Demolish 1 house (60 Sea Lane); partially demolish 1 house (45 The Ridings); construct 3 detached houses; alterations and extensions (45 The Ridings)
45 The Ridings and 60-62 Sea Lane East Preston

Thank you for your internet representation made on 8th May 2013 which has been recorded as '**an objection**' with the comments as follows:

STREET SCENES

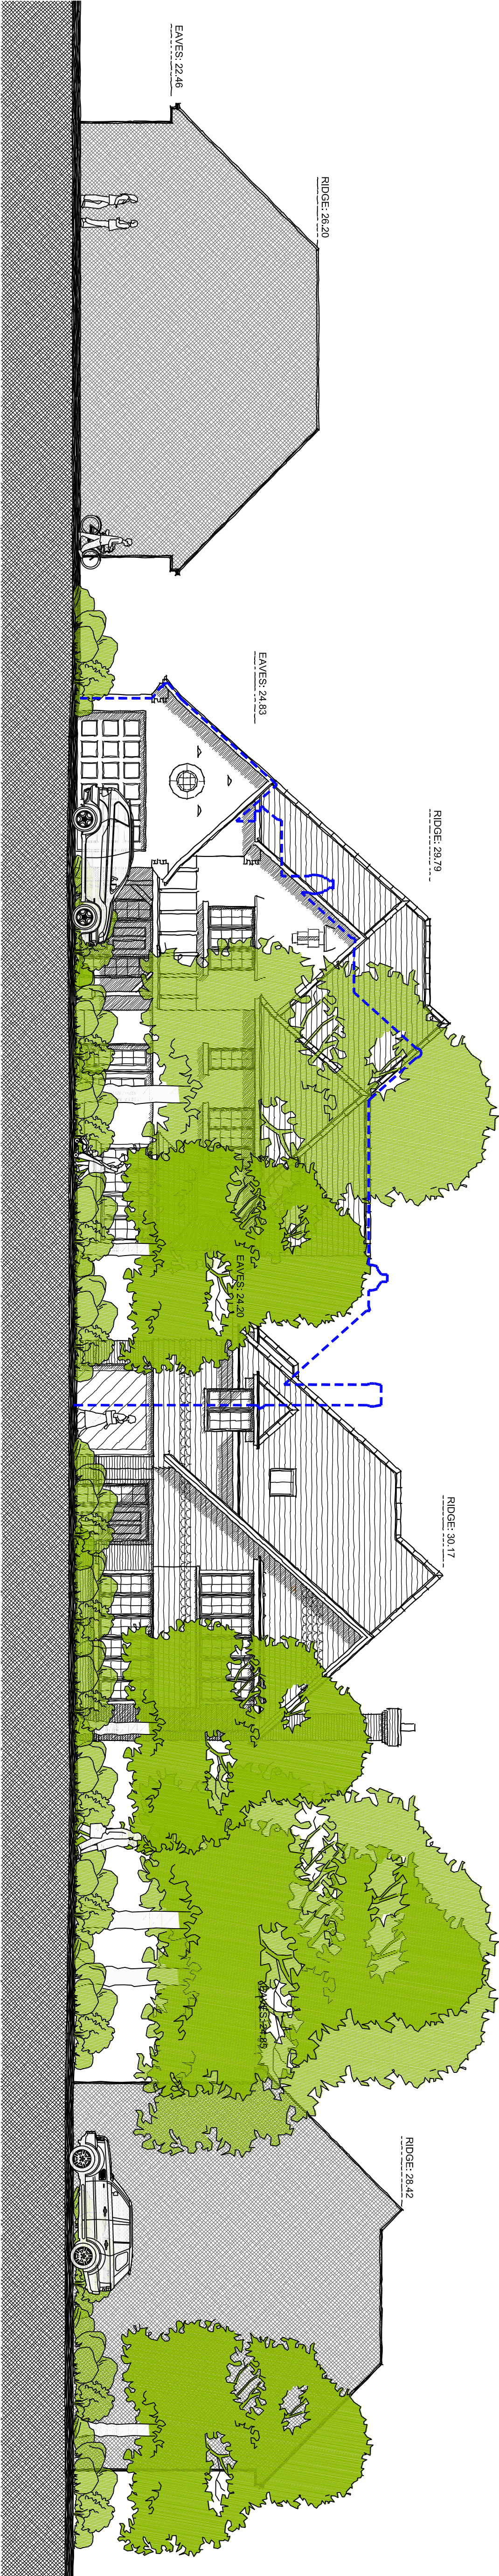
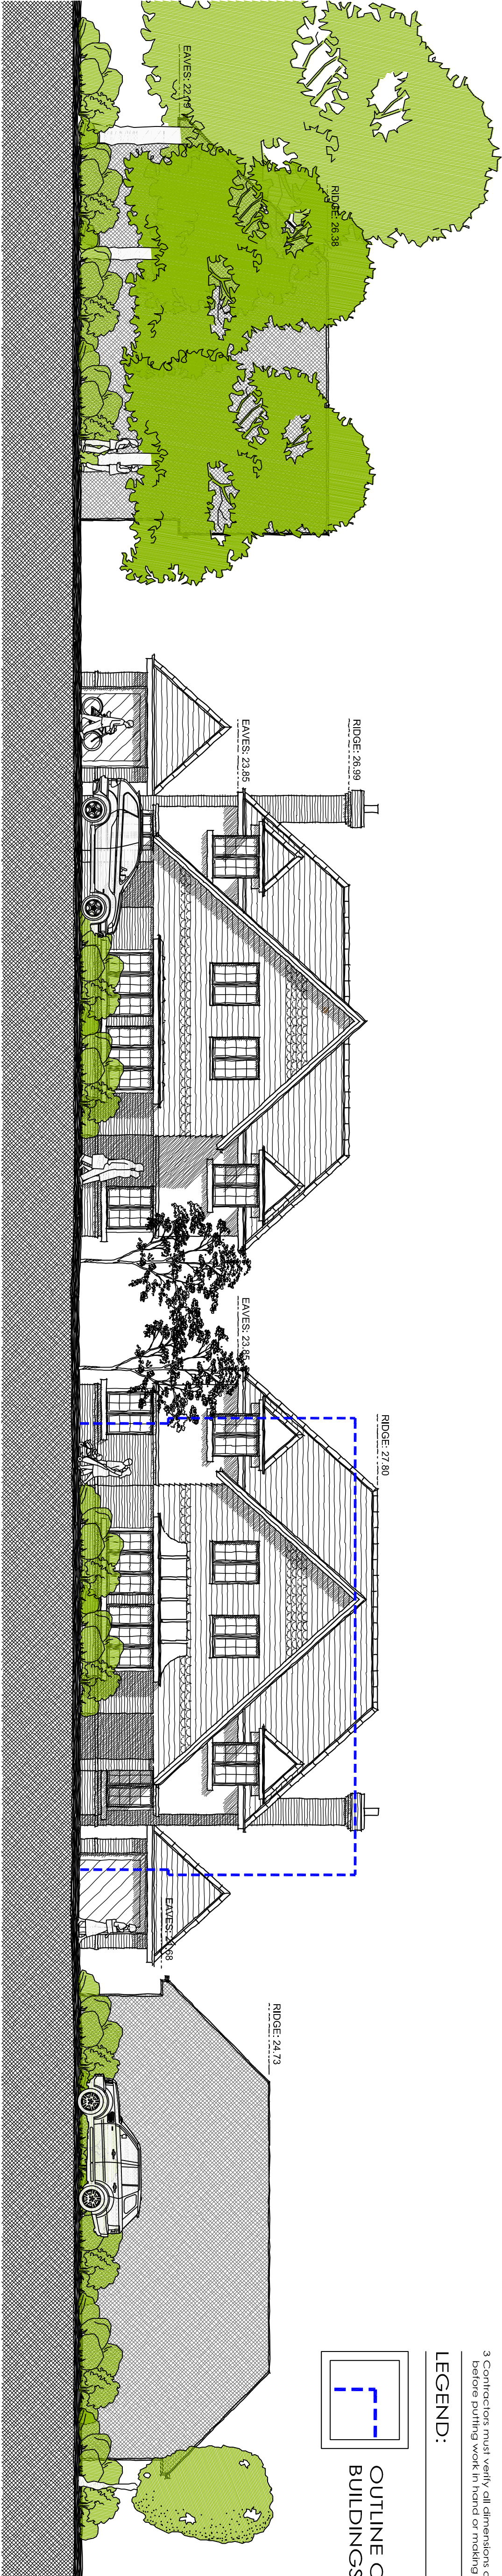
I contend that the new development of No 47 The Ridings and the proposed alterations to No 45 The Ridings will clash with their surroundings, as these dwellings will be significantly higher than those surrounding them. Elevation Drawing 8217/107 shows the existing property No 49 The Ridings to have a reference "ridge height" of 28.42 OD and the new No 47 to have a "ridge height" of 30.17 OD, which represents a 1.75m difference i.e. just under 6 feet, or the height of an average man. No 45 is being extended from a 2-storey to 3-storey dwelling with a given "ridge height" of 29.78OD, which is a significant increase in height also. Note that the EPVDS also states in this connection for houses listed as being in Character Area One that "attic rooms are permissible if they do not increase the height of the roof" and that "existing buildings should not be increased above 2-storeys". Aesthetically these developments will not benefit the immediate area of The Ridings or the Willowhayne Estate, indeed they will have a detrimental effect.
